EL PASO COUNTY PLANNING & COMMUNITY DEVELOPMENT SIGN APPLICATION

Name: God's Pantry
Address: 30 Widenfield
Blvd. Suit A

SHEET A1

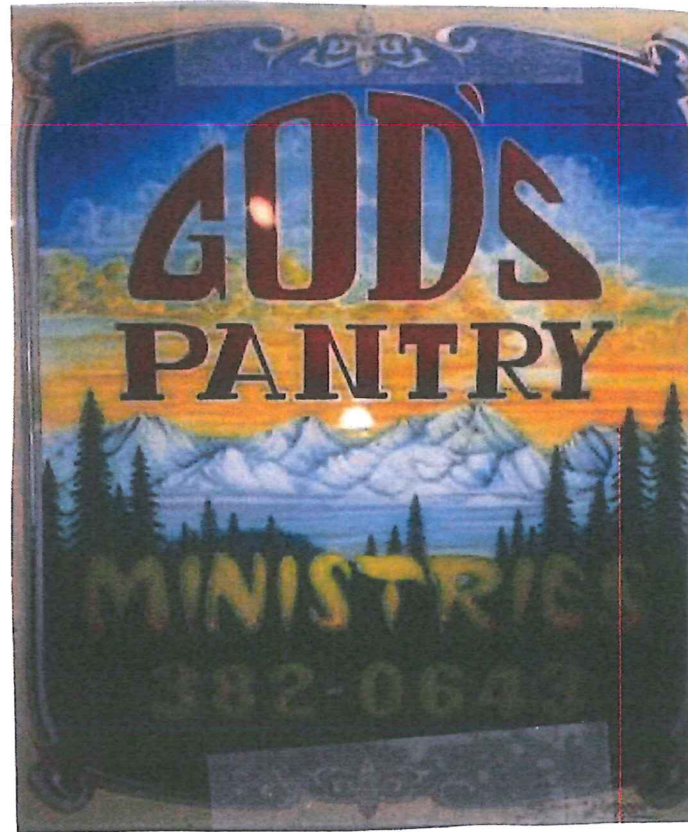
This needs to show
what the sign will look
like.

Show dimensions of sign.

Cant read this sign, measurements are off scale.

Sheet A2

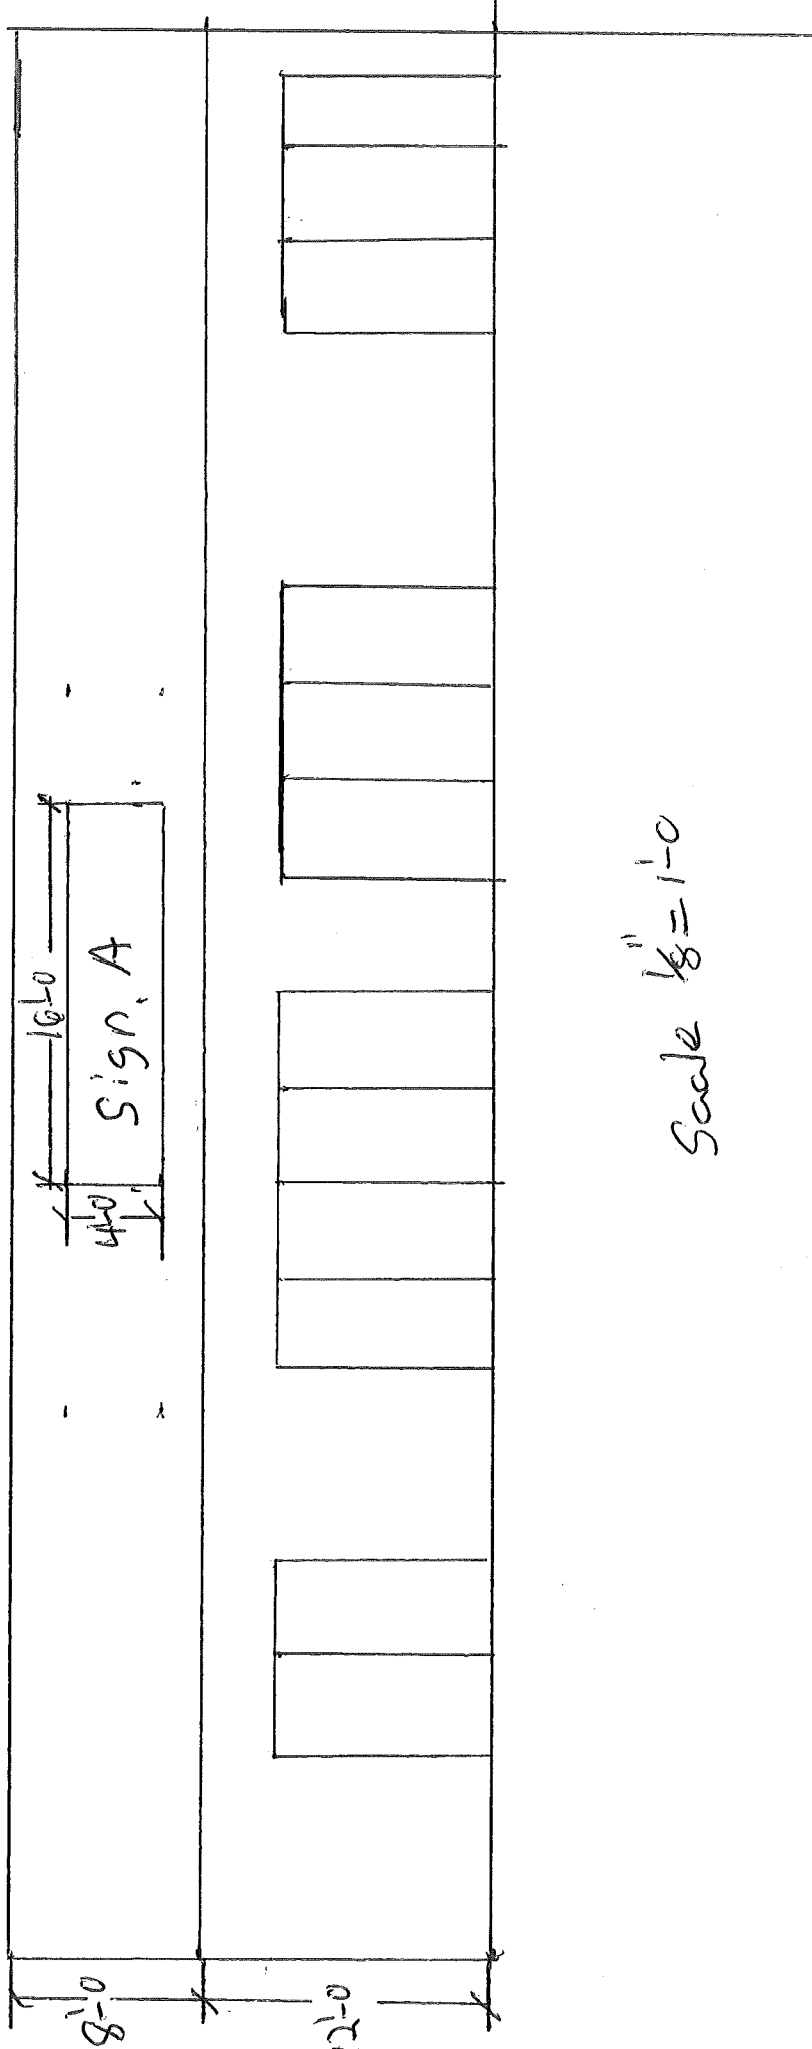
Show which sides of
the building the
proposed signs are
going to be.

Sheet
A4

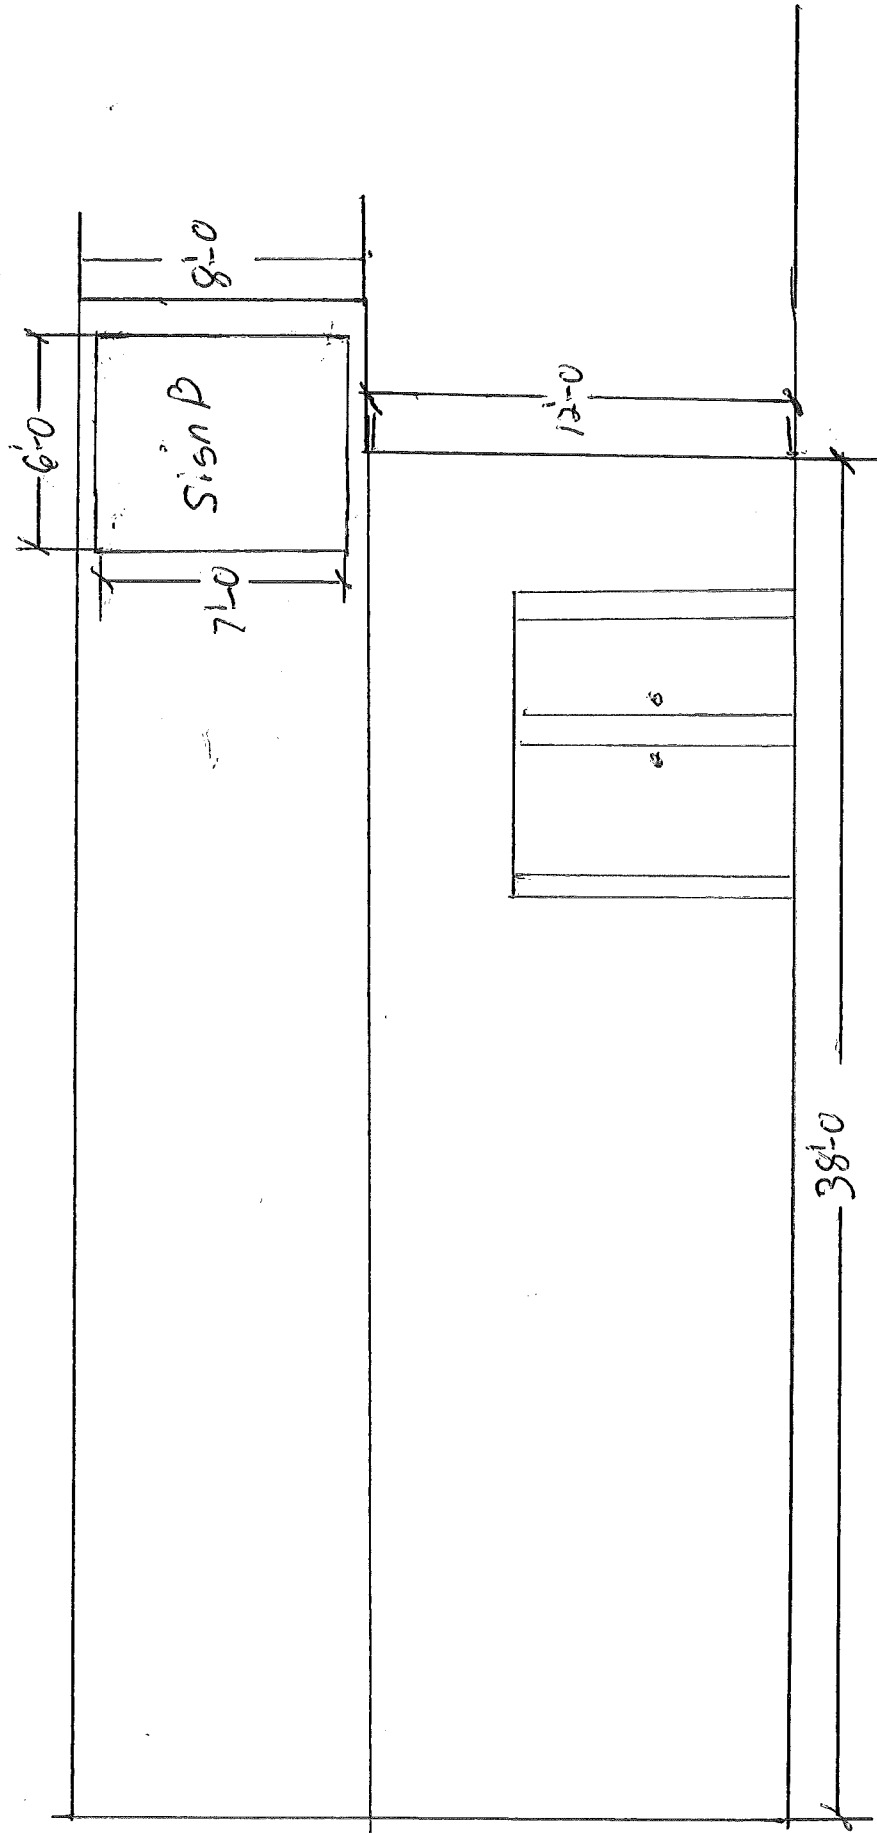
Show what elevation this is, front or side
